From: Gomez, Angela J.
Sent: Tuesday, August 04, 2020 2:16 PM
To: Gomez, Angela J.
Subject: FW: [#2020013] Wintergreen Apartments DRB questions (PR-2020-004030) (2)

The intent of this email is to provide responses to the questions raised by neighbors at the DRB hearing on July 22nd 2020, in regards to the proposed Wintergreen Apartment project City project number PR-2020-004030.

The updated plans to address DRB comments from the July 22nd hearing are available on the City website: http://data.cabq.gov/government/planning/DRB/PR-2020-004030/DRB%20Submittals/PR-2020-004030_Aug_5_2020_Supp/Application/DRB%20Resubmittal%207.31.2020/2020013%20DRB%20Plans%20-%20Wintergreen%20Luxury%20Apartments%20Resubmittal%207.31.2020.pdf

SECTION 1

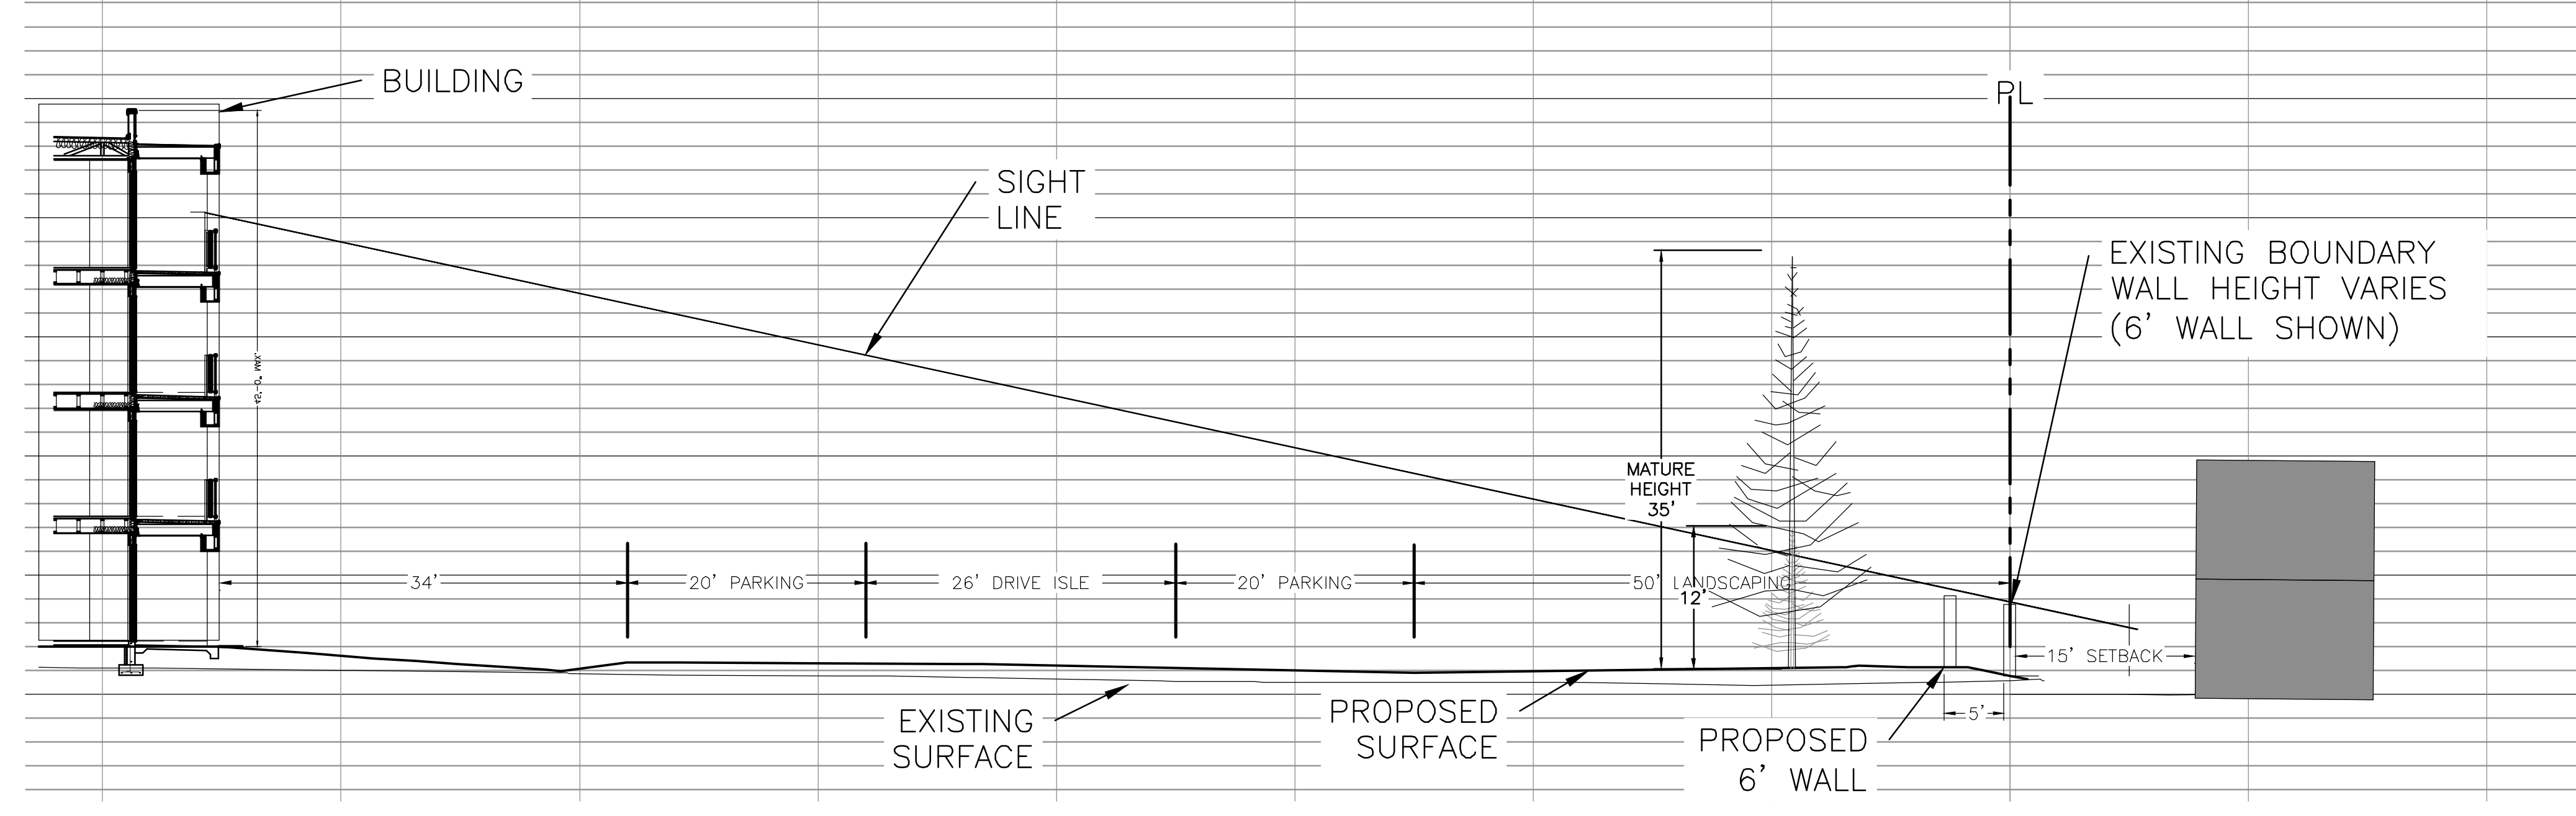
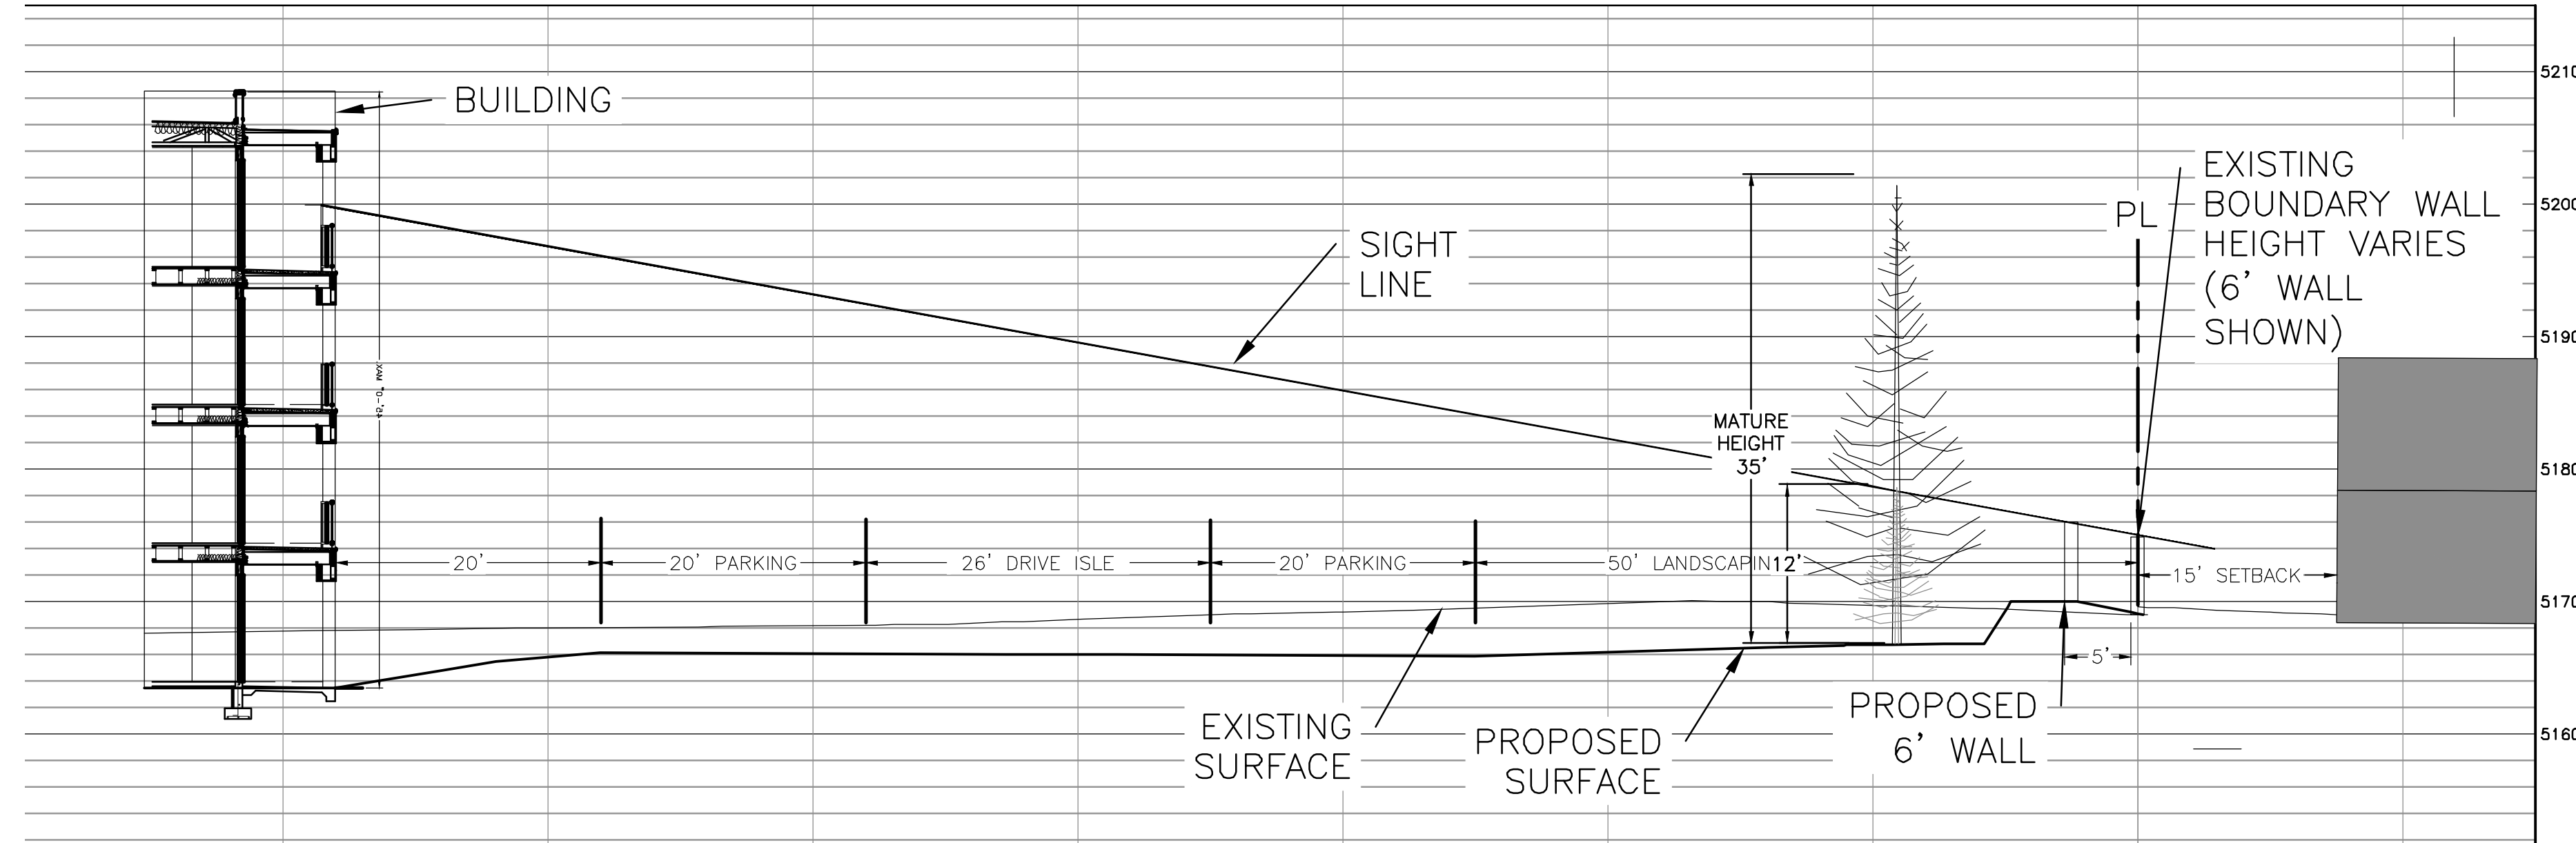
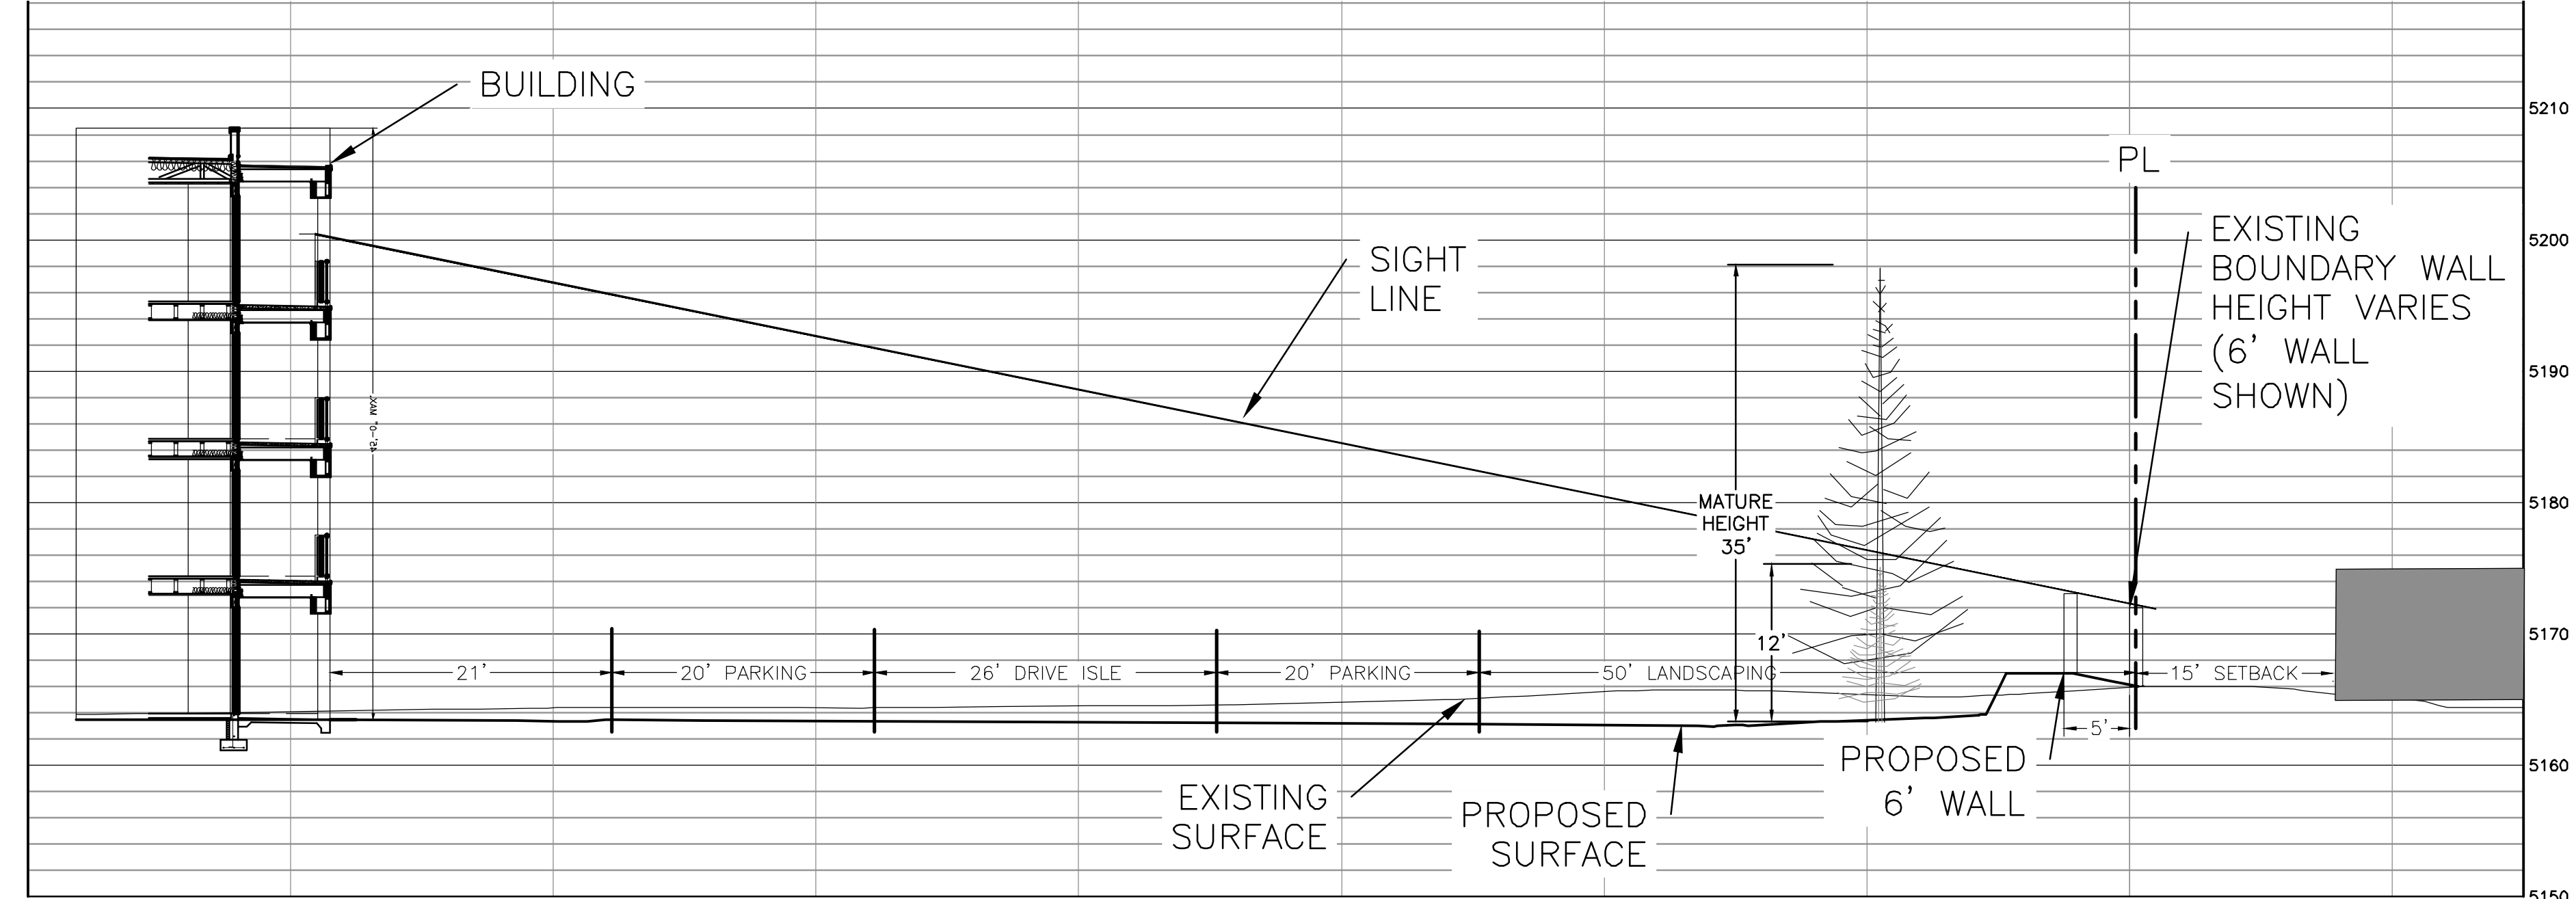
7. The cross-sections provided are inadequate when speaking to the privacy and noise barriers needed for the residents. Cross-sections show trees. Where exactly are they planted, spacing, heights, etc. We have no clear view of what will be in the buffer and how it will protect the adjacent property owners.

The tree sizes at planting and at maturity are shown in the cross sections to provide a scale and orientation of the apartment building relative to the single family homes and detail the buffer area. As previously mentioned the IDO requires a 50-ft landscape buffer (IDO Section 5-9(F)) to provide a setback between the improvements and the single family homes to increase the privacy and to reduce sight-lines from adjoining properties. Based on the proposed building height there is also a minimum 100-ft offset from the property line (IDO Section 2-4(C)), to provide protection to the adjacent home owners. Please refer to the landscaping plan which details the tree spacing, heights at maturity etc. which is included in the plans (link provided in previous email).

Response: A view plan exhibit was prepared to show the sections along the east half of the property and is attached to this email.
